The Five Village Society

Ref: Y/8/19/PL - Hazel Cottage, Church Lane, Yapton - Various
alterations and new extension
Heritage Statement (3 April 2019) from Heritage Consultancy
based in Essex - 39 pages.

PROJECT TITLE Proposed Development at Hazel Cottage Church Lane Yapton Arundel	DRAWING TITLE Proposed Elevations		No	REVISION	DATE
	STATUS Planning Application				
	SCALE 1:100 @ A3	DATE 03.01.2019			
	DRAWN BY DE	DRAWING NO PA-302-06

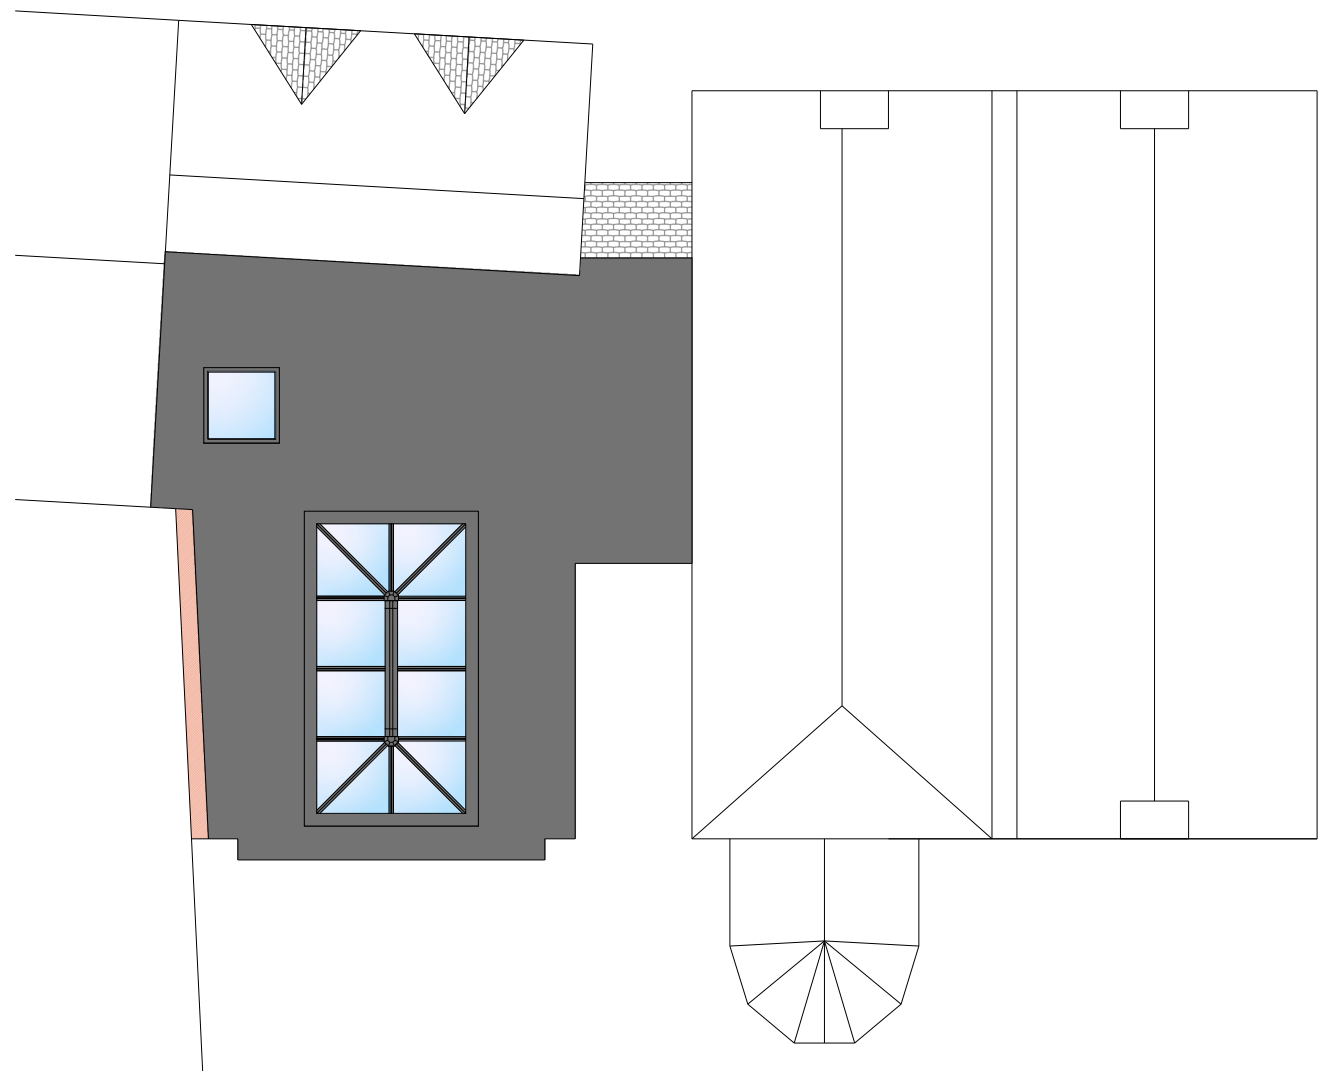
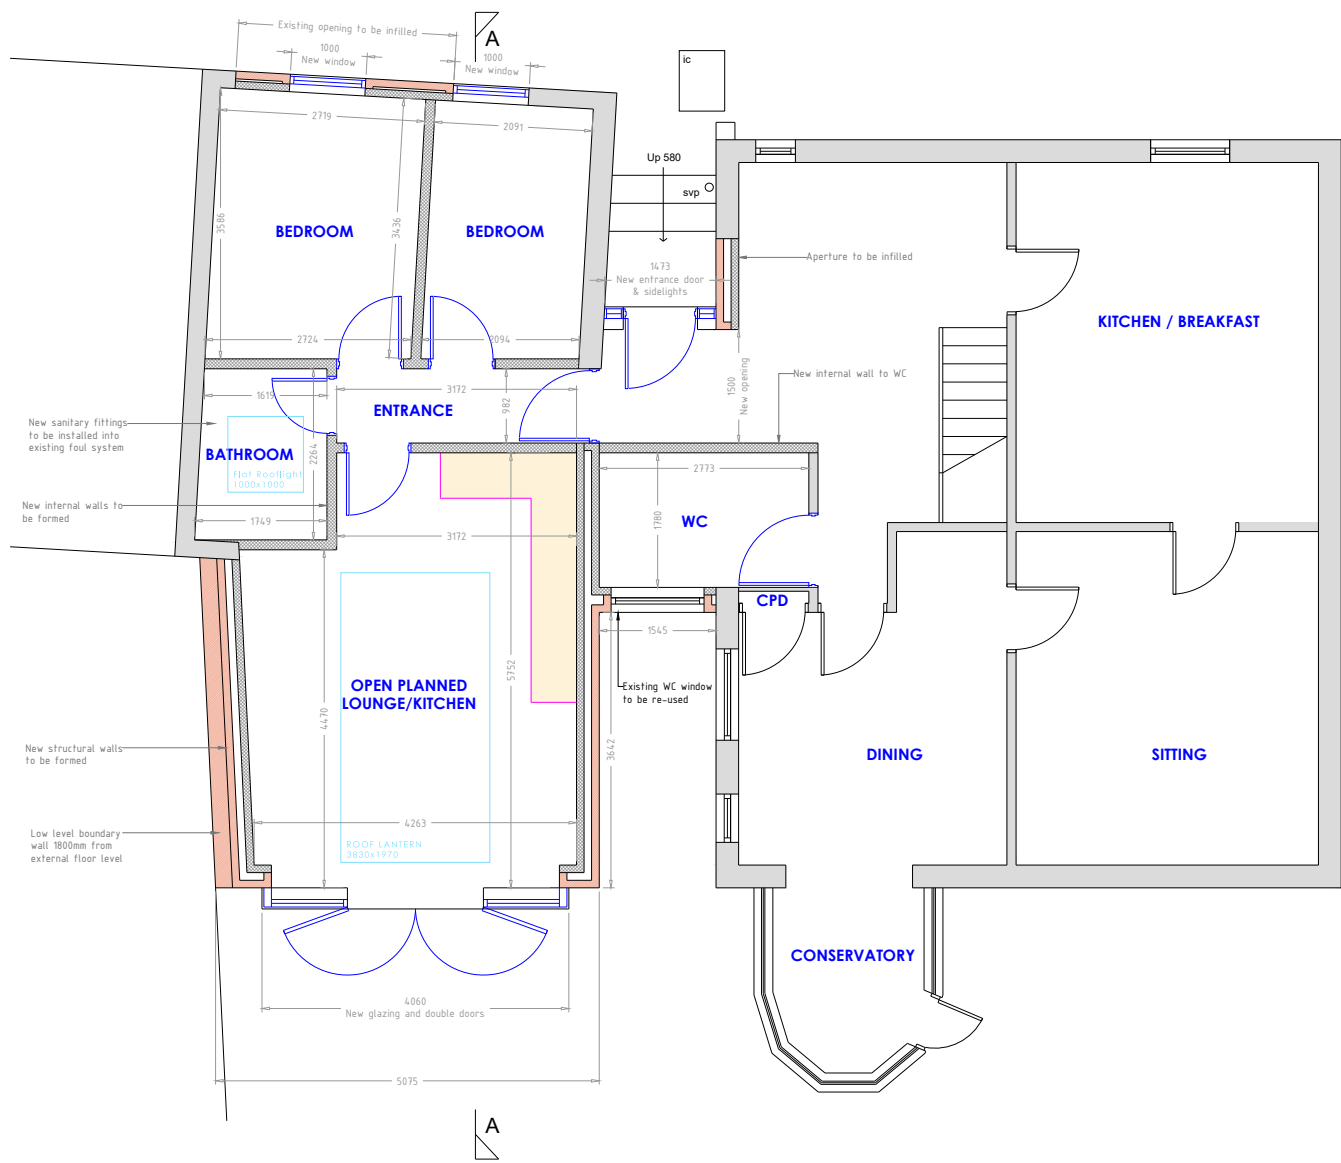
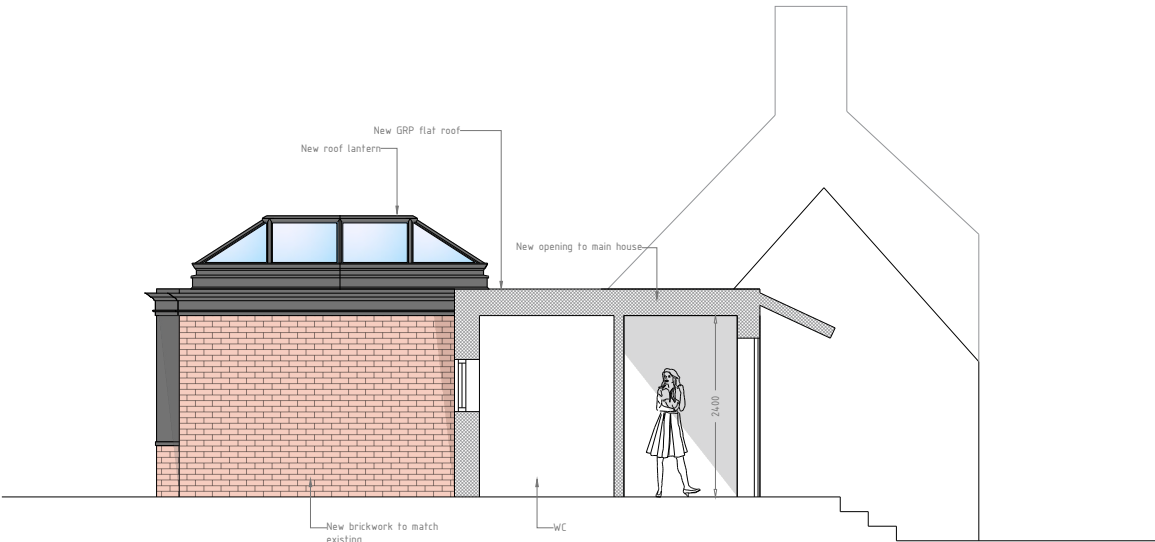
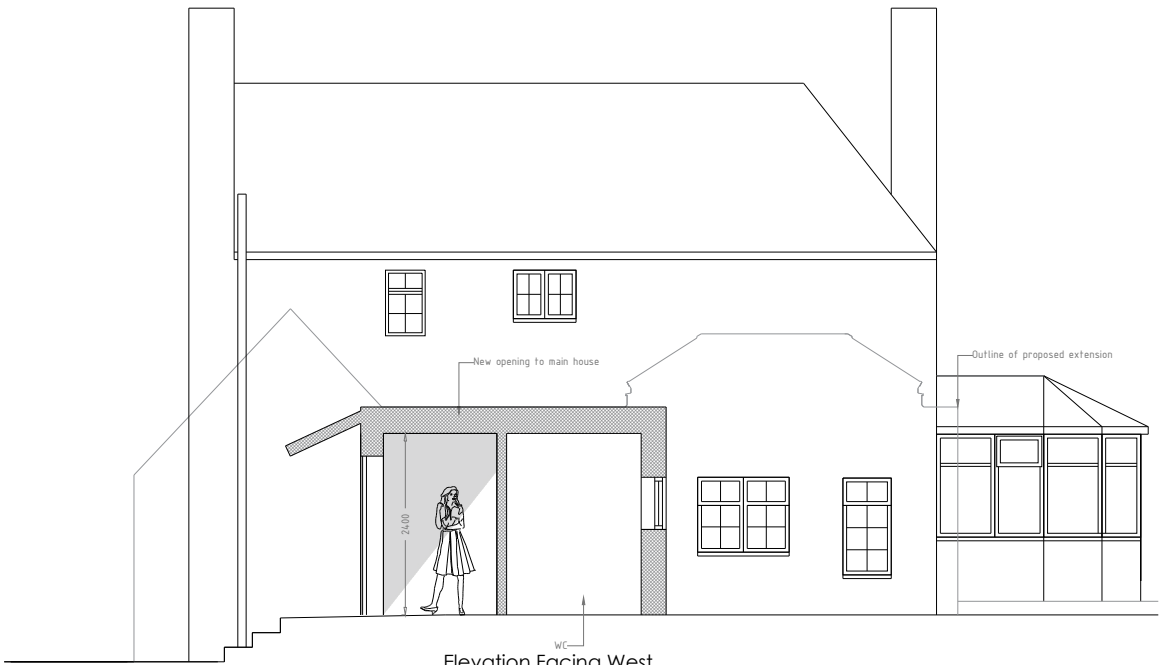
4. Any change to the simple tiles roof will affect the street
scene. Dormer windows design would be intrusive.
5. Can a garage be redundant?
6. What is the impact of the long wall of the rear extension on
the amenity of the garden of Twelfth of Never?
